Issue Specific Hearing 3 on Environmental Matters

Session 2: Carbon Savings

Submission from 7000Acres

Illustrative Layout Plan of Battery Energy Storage System and On-Site Substation

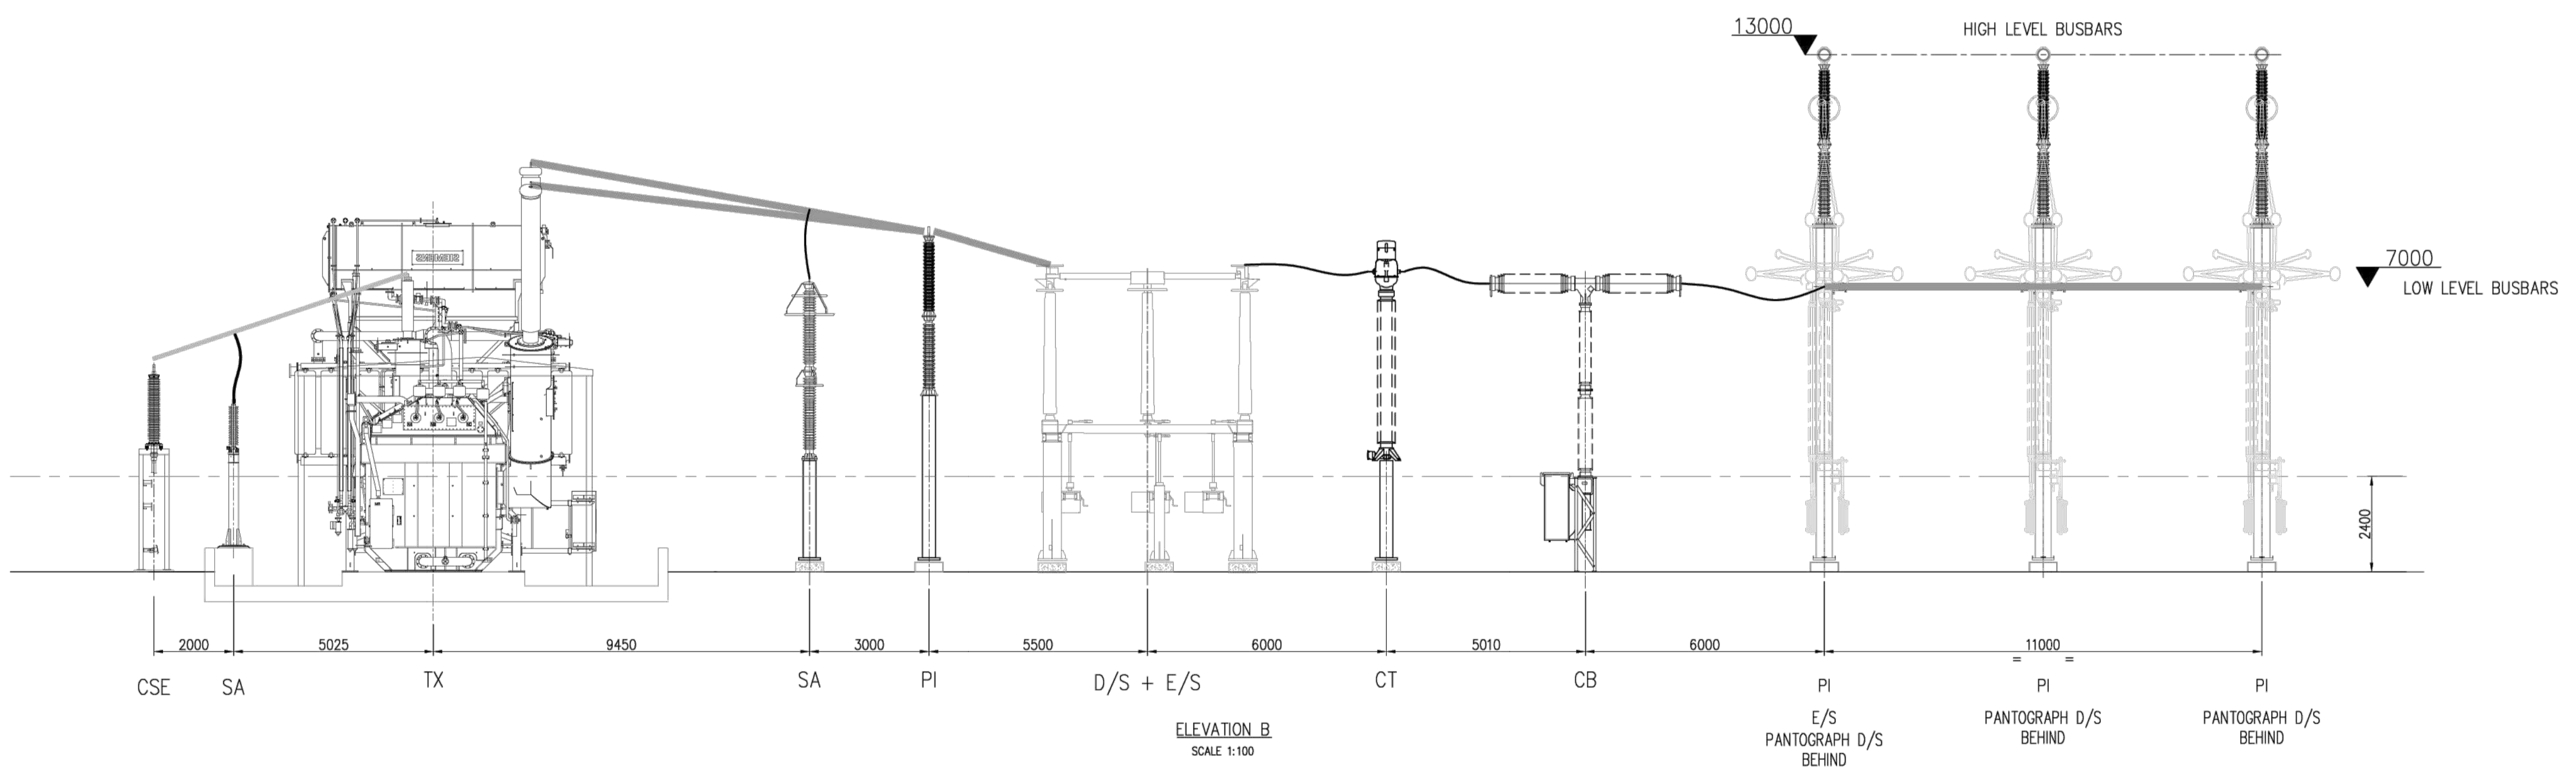
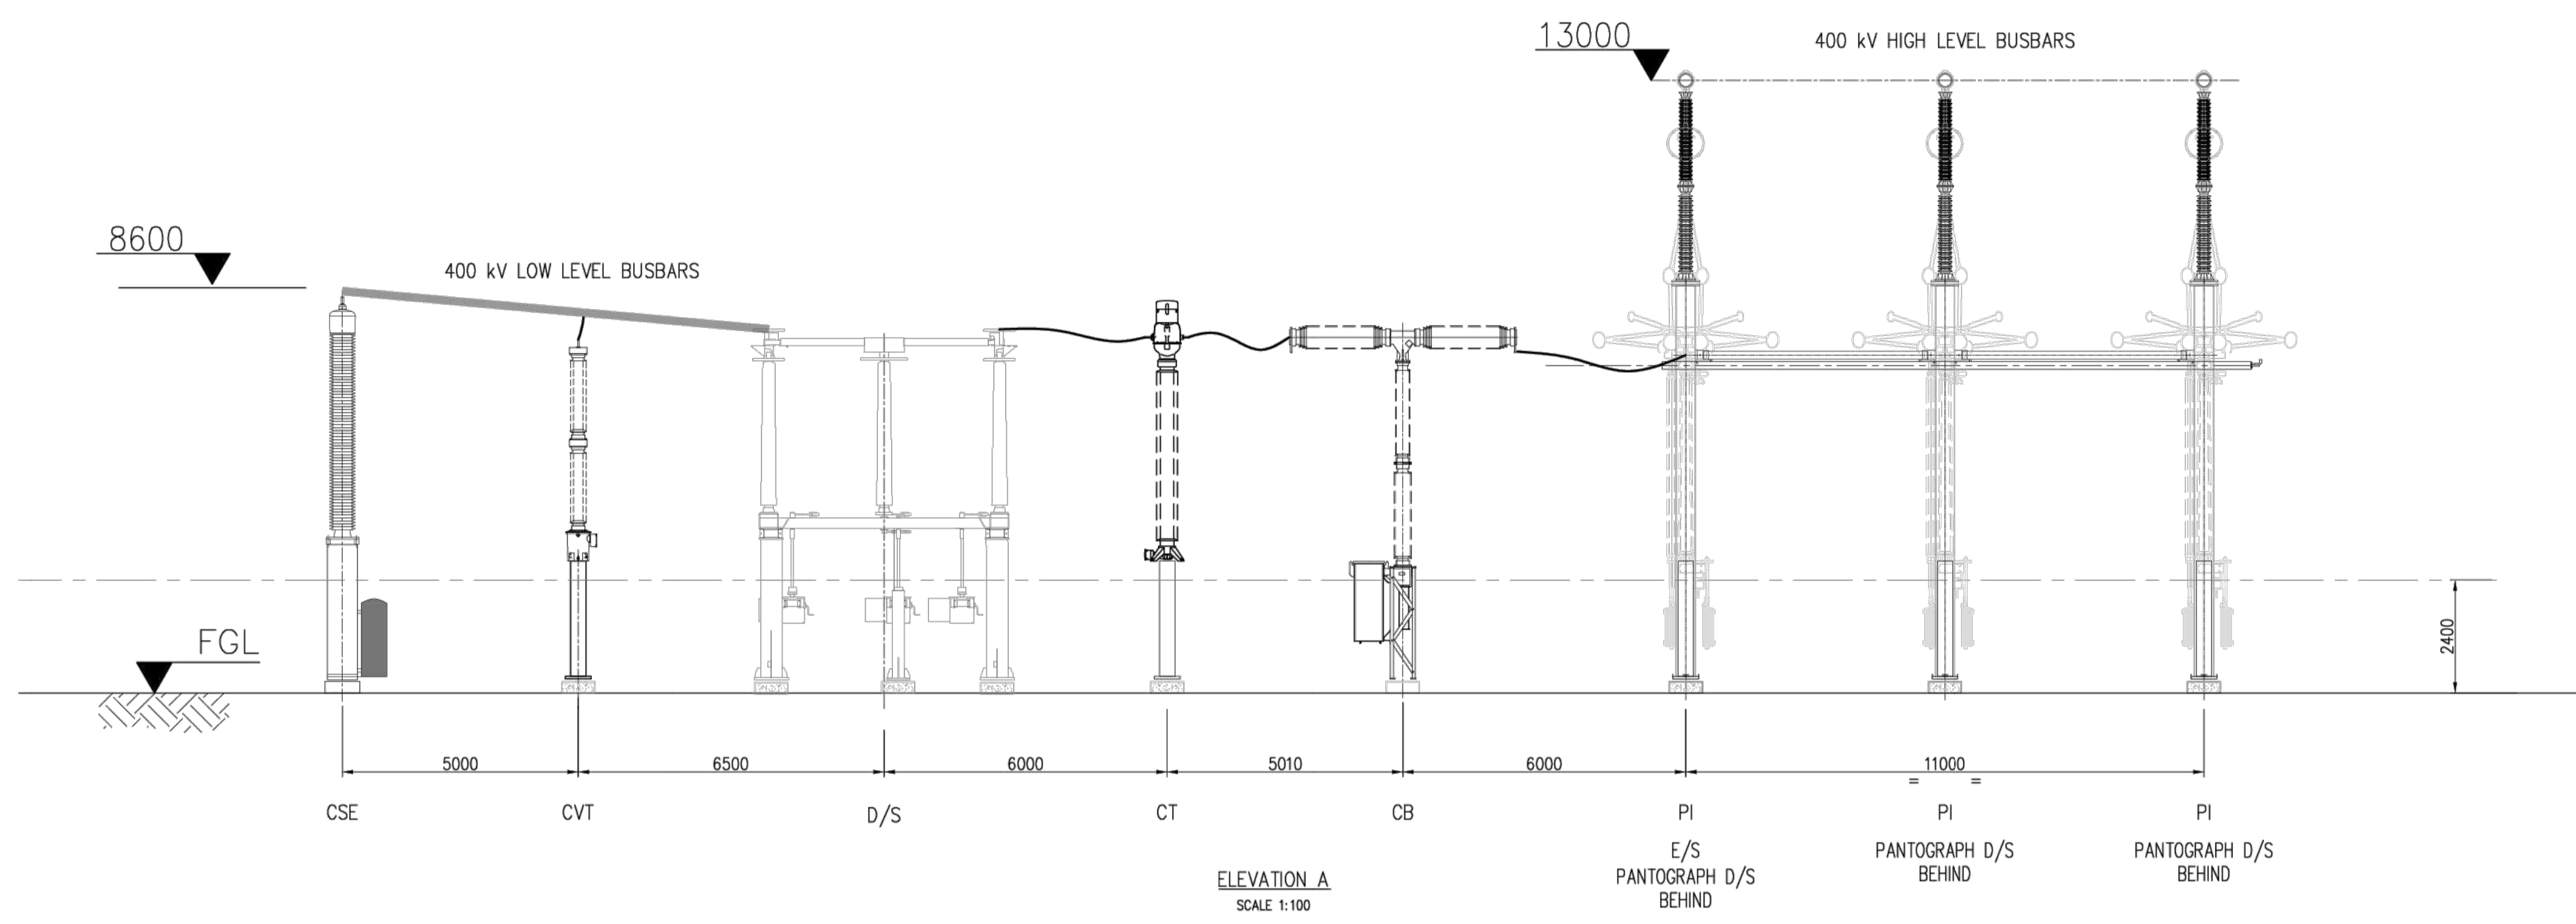
The BESS containers are situated 3m apart, which is contrary to the National Fire Chief Council Guidance of 6m apart. This must be corrected and secured in Work No 2.

There is no bunding around the BESS enclosures identified in Work No. 2. In the event of a thermal runaway this could result in large volumes of contaminated fire water, containing hydrofluoric acid, entering the local ecosystems. Suitable bunding must be included in Work No.2. Due to the potential for highly contaminated firewater being released into the local environment, the Environment Agency should be consulted on the BESS design.
